**RE: Comment Response Letter to E-911 and School District No. 49 Comments:
The Markets at Bent Grass, SP262 & CR261
Preliminary Plan & Rezoning**

Please find below responses to comments received from the El Paso/Teller County 911 Authority and Falcon School District 49 regarding the Markets at Bent Grass Preliminary Plan and Rezoning applications.

PRELIMINARY PLAN
THE MARKETS AT BENT GRASS
EVERGREEN DEVELOPMENT
EPC FILE #: SP262

LOT & TRACT PLAN

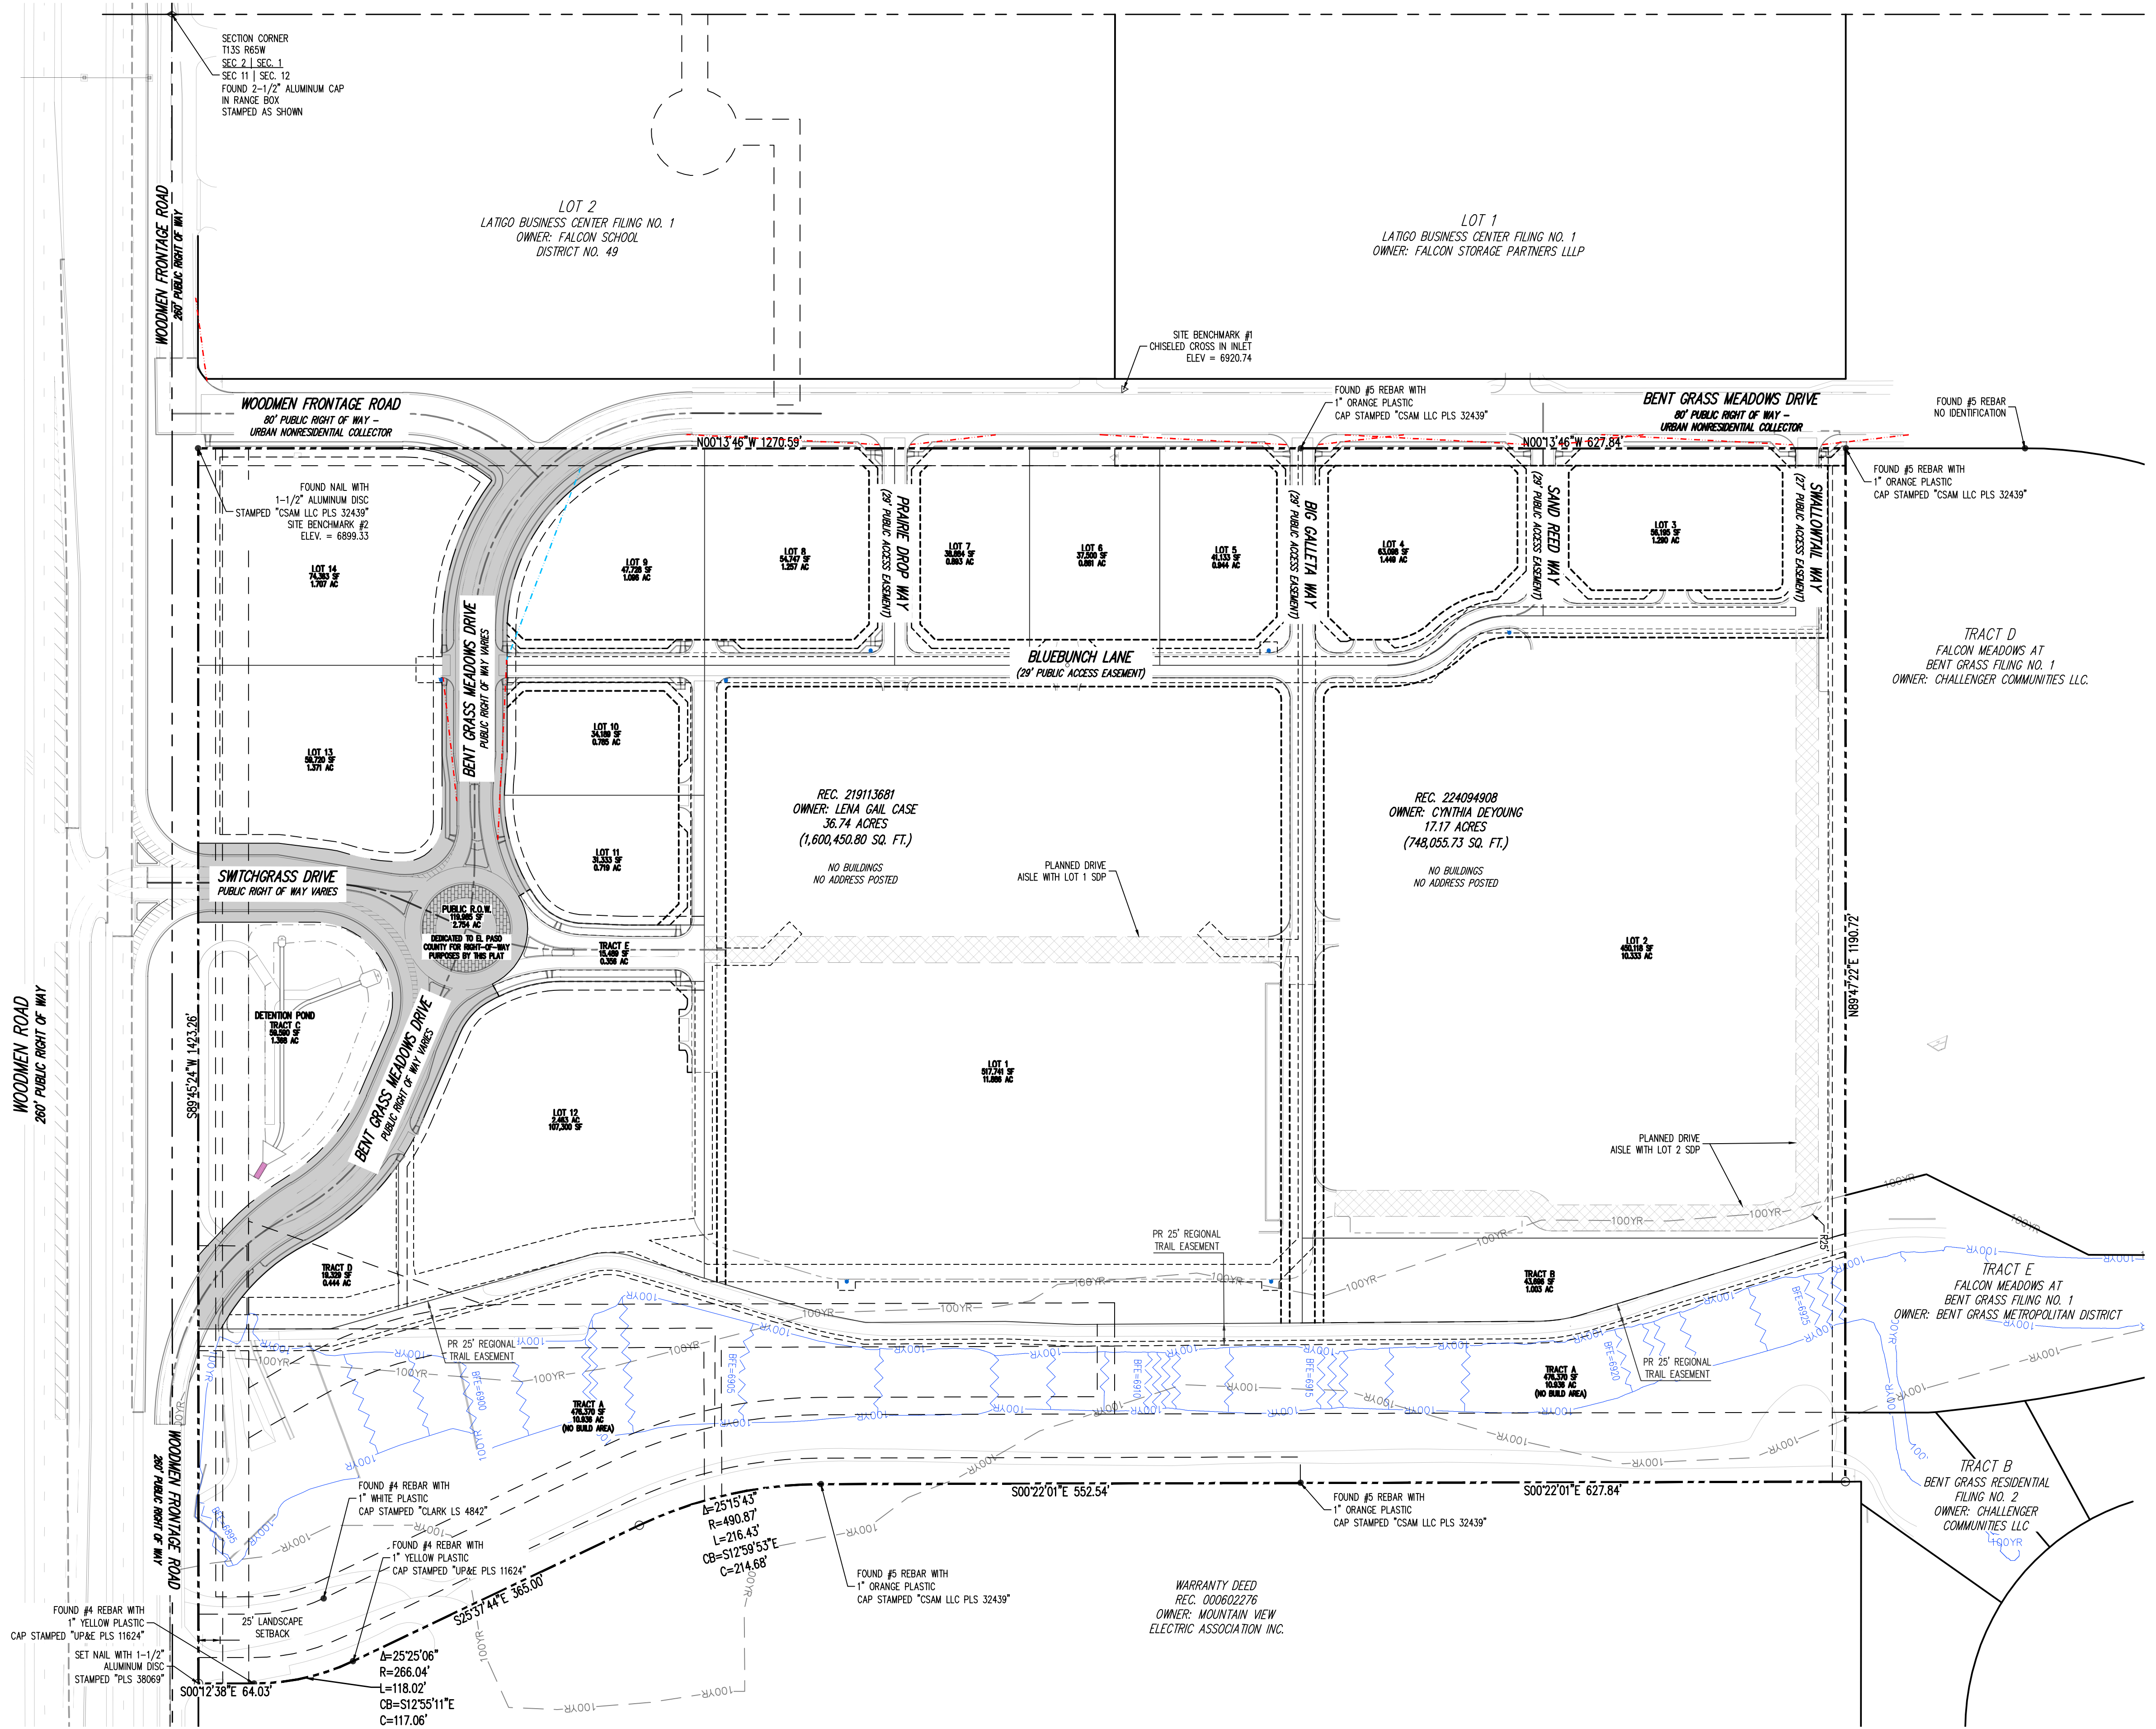
A resolution regarding the interaction between Bent Grass Meadows Drive and Woodmen Frontage Road is still pending. We are awaiting confirmation from the developer regarding a possible address change for one parcel to determine how to move forward.

- *Swallowtail Way*
- *Big Galleta Way*
- *Prairie Drop Way*
- *Bluebunch Lane*
- *Switchgrass Drive*

Sand Reed Way – Not Available (existing roadway name).

In response to comments received from E-911 and PPRBD Enumerations, as well as the meeting held on April 21, 2026 with E-911, Enumerations and County Staff, the applicant has proposed to rename both (i) the section of proposed roadway east of the proposed roundabout and (ii) the existing section of Woodmen Frontage Road (from the proposed roadway to Falcon Marketplace) to **Bent Grass Meadows Drive**, as reflected on Preliminary Plan Sheet No. 3 attached hereto.

This change is in direct response to E-911's concerns about emergency service response with the previously proposed road name change occurring at the proposed roundabout. As discussed with E-911 and Enumerations, such road name change will result in the need for a single neighboring property to revise its current Woodmen Road address. Applicant has notified the neighbor of this change, and they have indicated a willingness to cooperate. Applicant has scheduled a meeting with the neighboring property owner, E-911, PPRBD Enumerations, and County representatives to finalize a resolution.

Additionally, the roadway previously identified as **Sand Reed Way** has been removed from the Preliminary Plan in response to unrelated County engineering comments. Based on the applicant's review, no further modifications related to roadway naming are believed to be necessary. As of the date of this letter, all other proposed roadway names appear to remain available.
